KIRKLEES METROPOLITAN COUNCIL INVESTMENT & REGENERATION SERVICE

DELEGATED DECISION TO DETERMINE PLANNING APPLICATIONS

Reference No:	2025/62/91493/E
Site Address:	24, Pollard Avenue, Gomersal, Cleckheaton, BD19 4PP
Description:	Erection of single storey rear and side extension
Recommending Officer:	Edward Cheseldine

HOUSEHOLDER DELEGATED REPORT

Revision History			
RevID	ChID	Change Name	Date
Proposed Single Storey Extension			
24 Pollard Avenue			
Gomersal			
Cleckheaton			
BD19 4PP			
Drawing Name			
Drawing Status			
Modified by			Date
Checked by			Date
Drawing Scale			1:50
Layout ID			Revision
(PL) 003

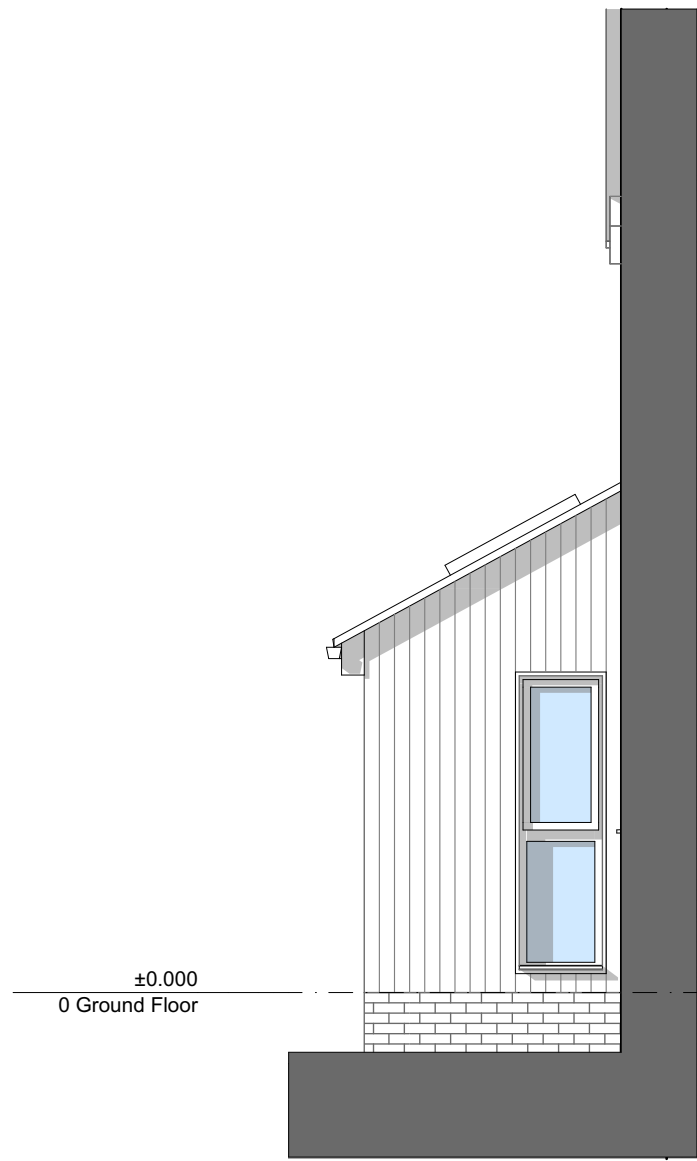
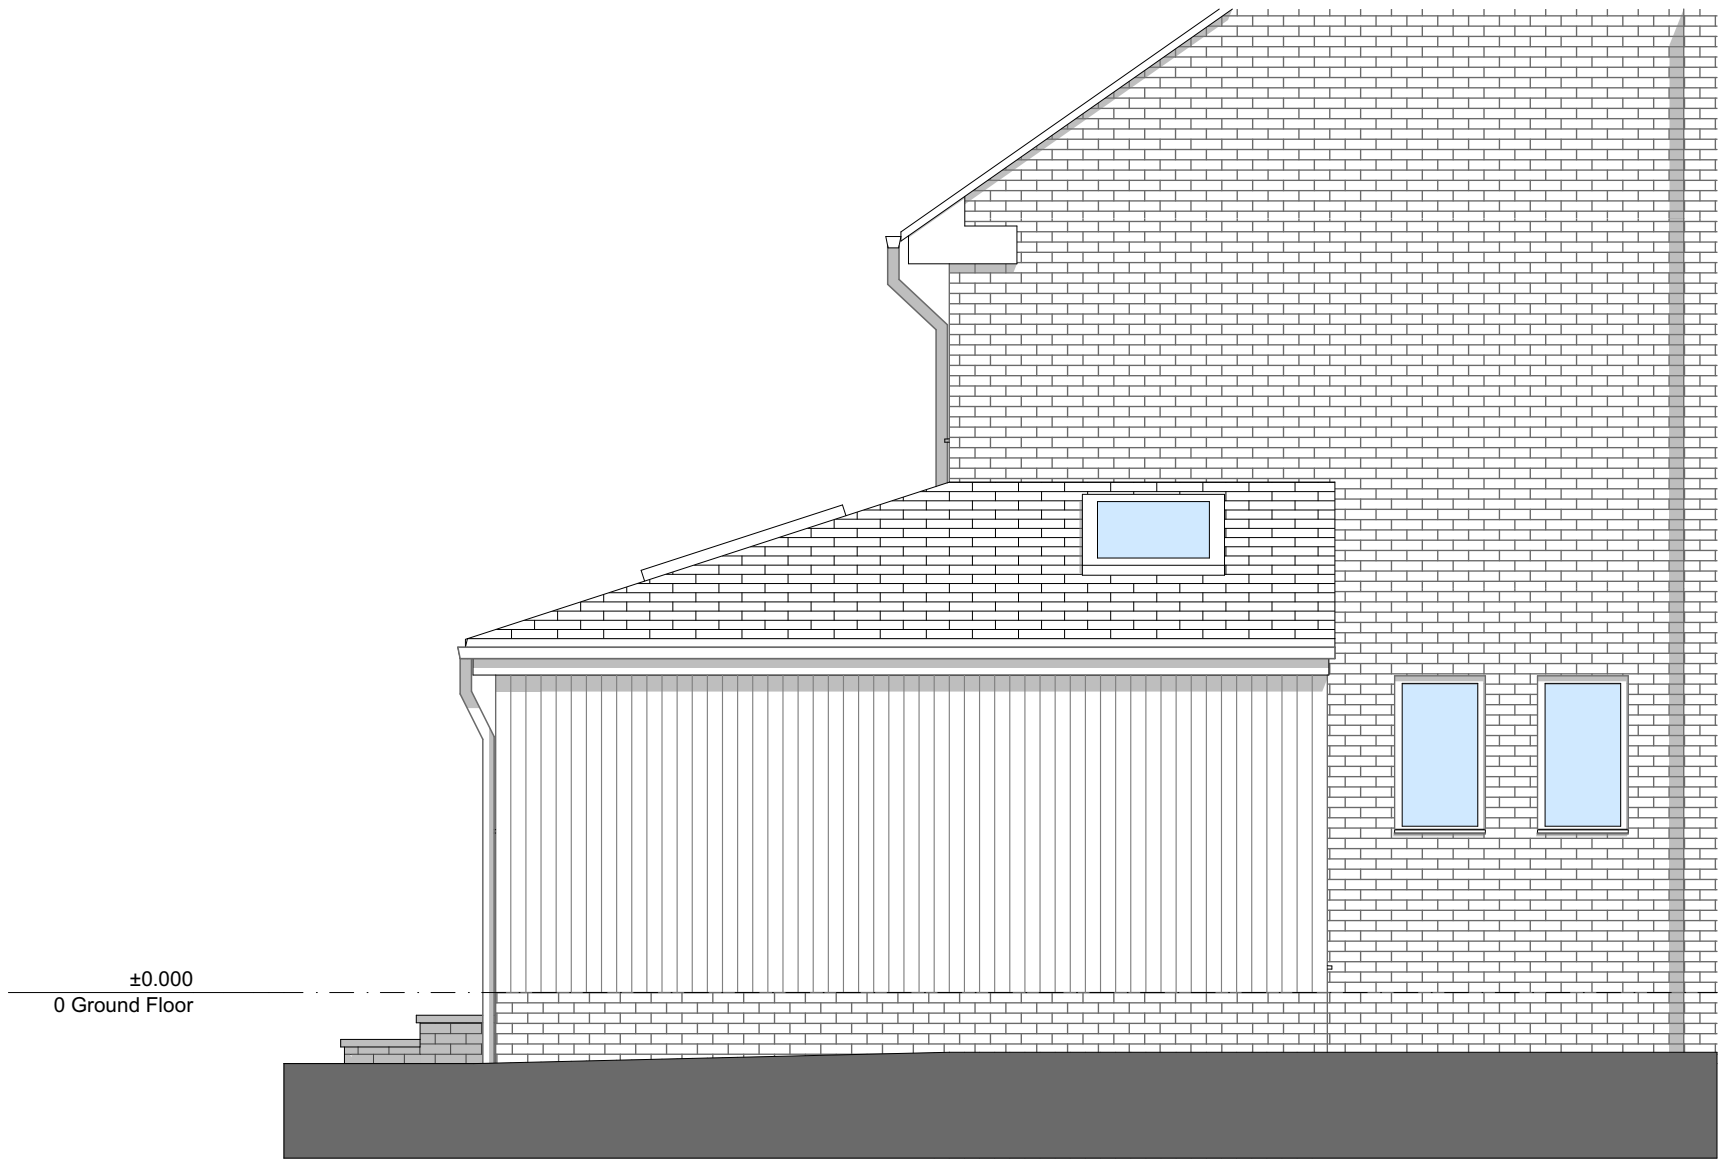
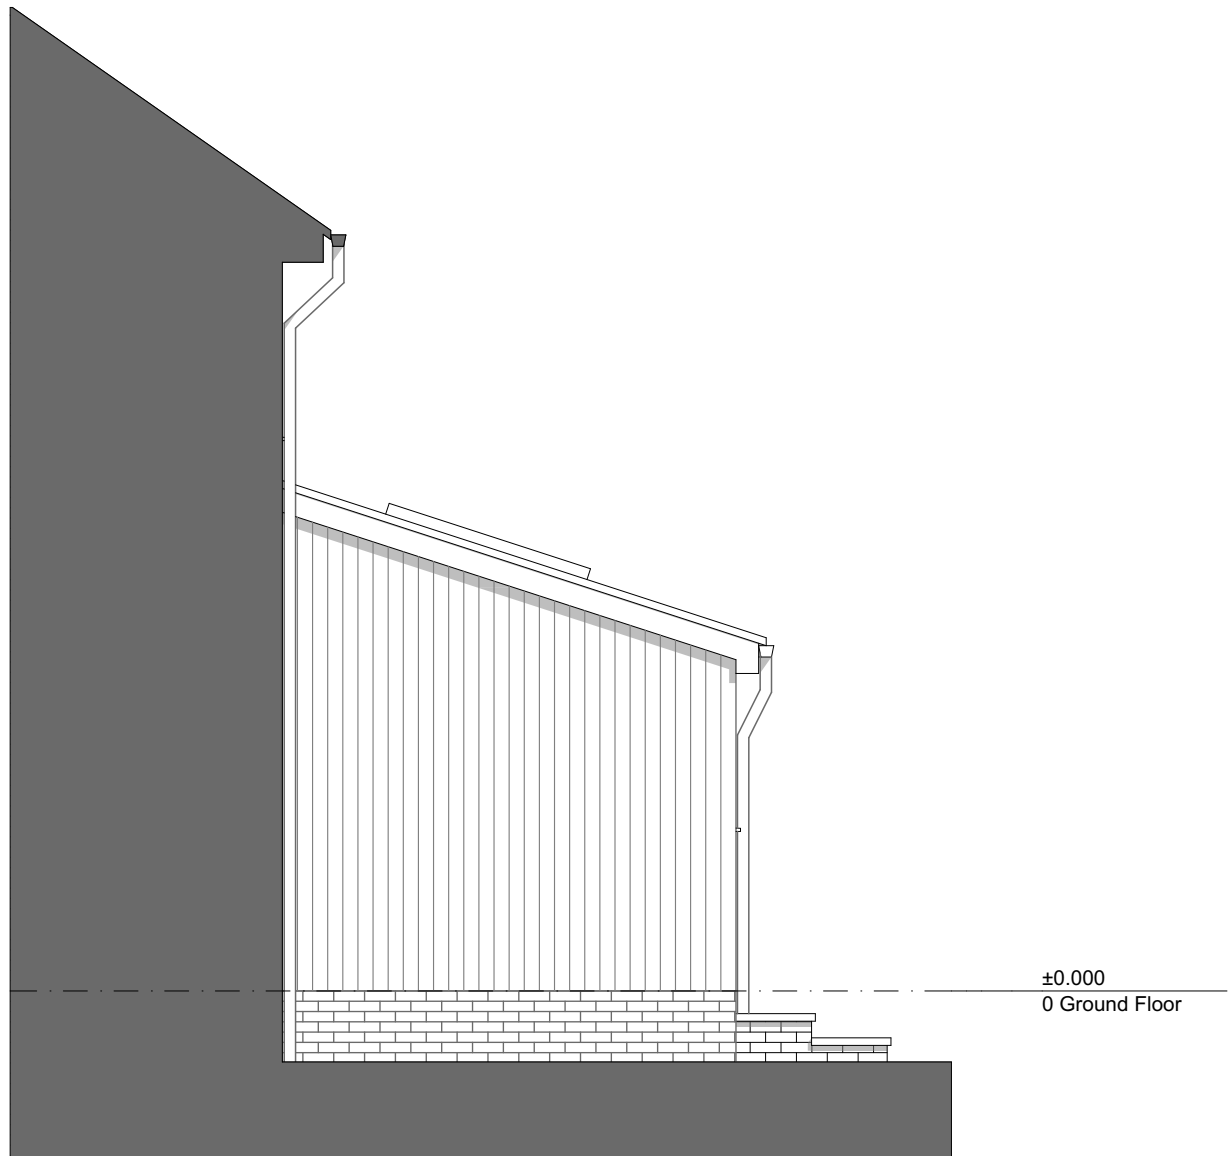
Relevant key design principle (KDP) of the SPD, Policy in the Kirklees Local Plan and the NPPF	Further comments	✓ / X / N/A
Impact on privacy of neighbours (to sides, rear and front)	- KDP 3 & 4 of the SPD - Policy LP24 Design (d) (iv) - Chapter 12 of the NPPF	In terms of privacy, there will be a new skylight which faces towards this property group. As it is high level and angled, it

is not considered to impact upon privacy of neighbouring occupiers. A kitchen window will be divided due to the creation of a w/c area. It will be conditioned this window is obscurely glazed to protect the privacy of future and neighbouring occupiers.	
Impact on light and outlook of neighbours (to sides, rear and front)	• KDP 4, 5, 6 of the SPD • Policy LP24 Design (b) • Chapter 12 of the NPPF	The side extension will be constructed which will move built form towards this property row. There will still be the retention of a 1.00m side space to the boundary. The side extension is single storey. Due to its placement and height, it is not considered the side extension will lead to a loss of light or outlook.

3. The external walls of the extension shall be constructed with cedar wood cladding and brick course exteriors, whilst the roofing materials of the extension shall be constructed with concrete roof tiles, as indicated on drawing reference (PL) 003.

4. The development shall not be occupied until the W/C window in the side elevation of the extension hereby approved has been obscurely glazed (to a minimum Grade 4). Notwithstanding the provisions of the Town and Country Planning (General Permitted Development) Order 2015 as amended (or any Order revoking or re-enacting that Order) the obscure glazing (to a Grade 4) shall thereafter be retained.
